From: Amanda Scholes on behalf of Planning.Responses
Sent: 07 December 2017 09:03
To: Planning Scanning
Subject: FW: Y/65/17/HH Rumford, Church Road

Application Number	<u>Y/65/17/HH</u>
Address	Rumford Church Road Yapton BN18 0EW
Description	Buttressing & repair of failed flint wall. This application affects the setting of a Listed Building & the Character & Appearance of the Yapton (Main Road/Church Road) Conservation Area.
Case Officer	<u>Mr R Temple</u>
Date	5 th December 2017

Flint wall repair Proposed Plan and section

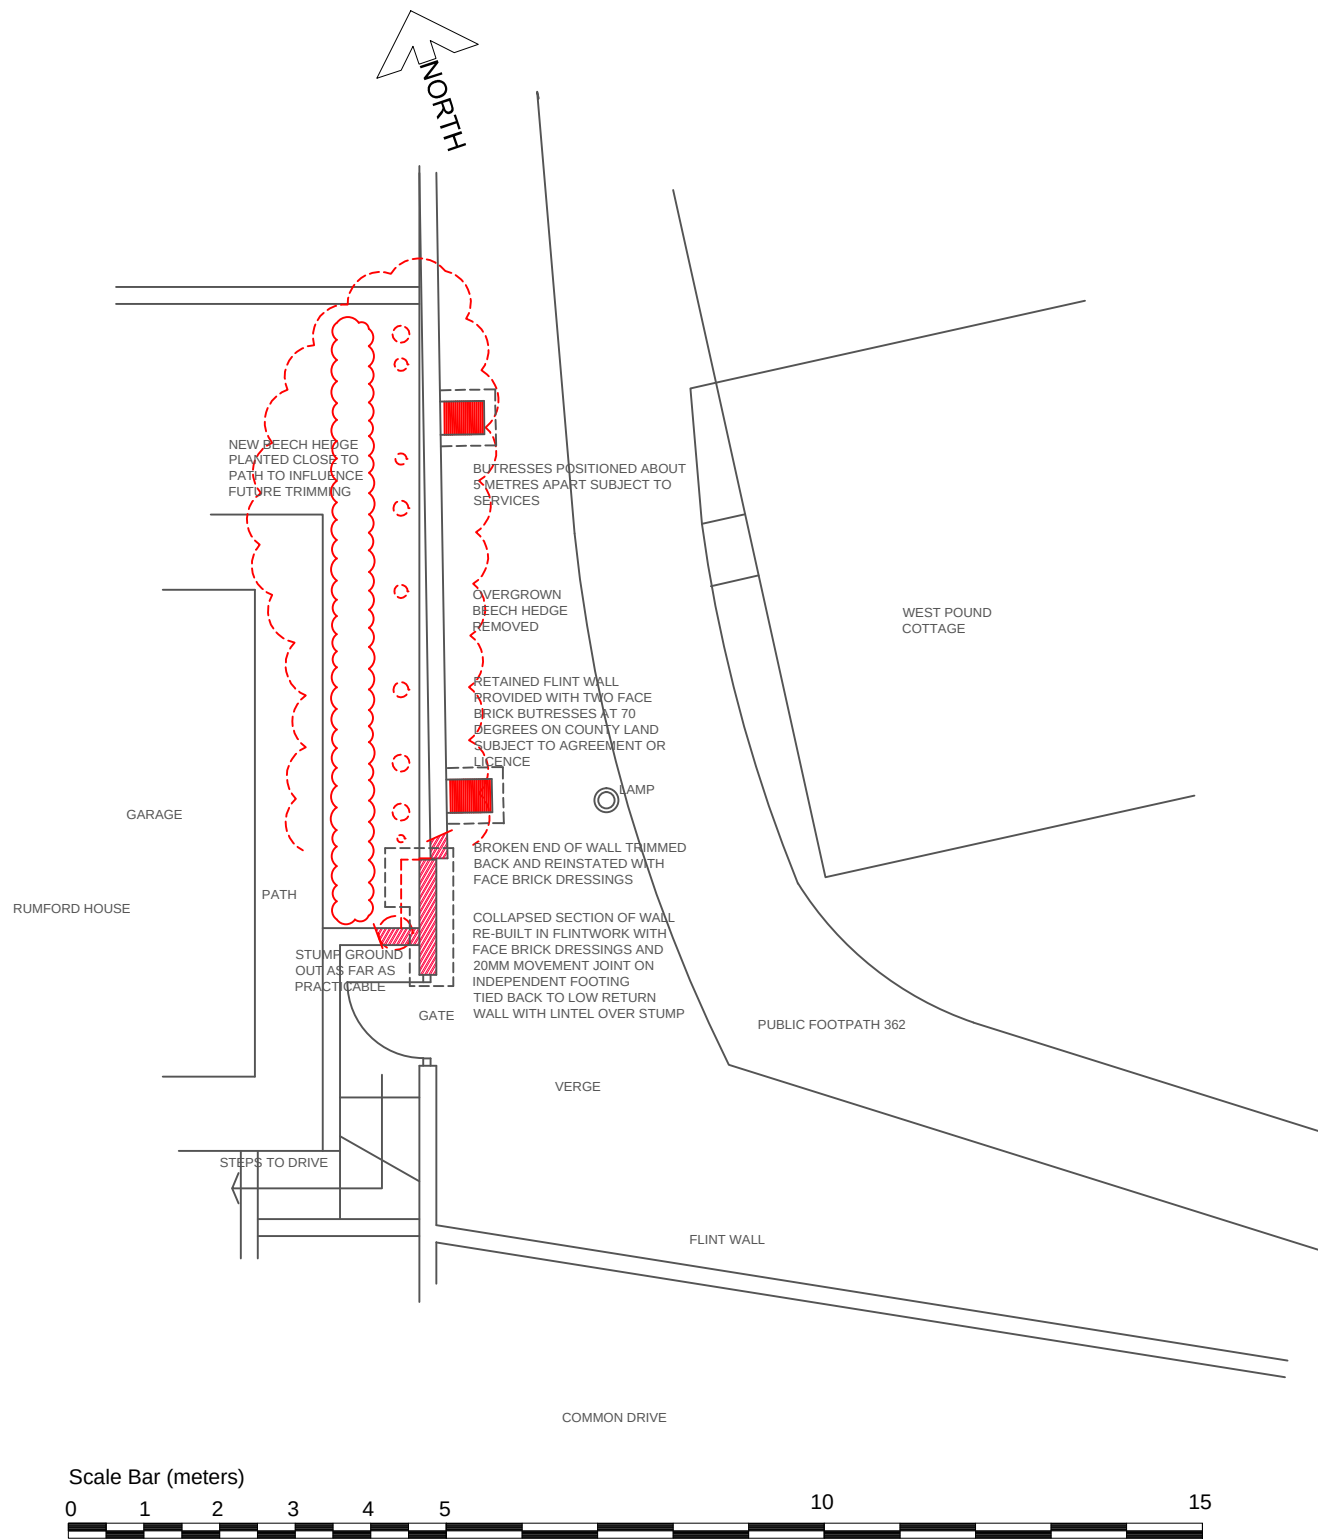
A section of the wall has collapsed, and submitted plans show the insertion of brick facings between existing and new flint work, a movement joint, together with the insertion of 2no. brick buttresses in concrete footings.

While there is no objection to the repair of the collapsed section of wall, in suitable lime mortar, re-using the flint cobbles, it is not normal practice to insert a brick facing, nor piers, nor piers in a foundation as drawn. It is considered that the proposed is visually intrusive and upsets the visual harmony of the run of wall, and therefore I object to this application.

It is suggested that the collapsed section of wall is rebuilt using suitable lime mortar, with existing cobbles, capped to match existing. Should a structural survey suggest increased structural support is deemed necessary, the use of Helifix or a similar could be considered within the core of the wall. Any structural issues that are found to exist should be ascertained by a suitably qualified person, and be addressed accordingly via the usual process.

We are not at all happy about this, nor should we be; this objection is late, yet you allow no time to answer it; some of the points raised we may well agree with, some we do not. The wall is inevitably falling down, buttresses are the traditional way of avoiding that, there are two within about 50 metres of the site, but whatever the solution may be, there is a need to do something.
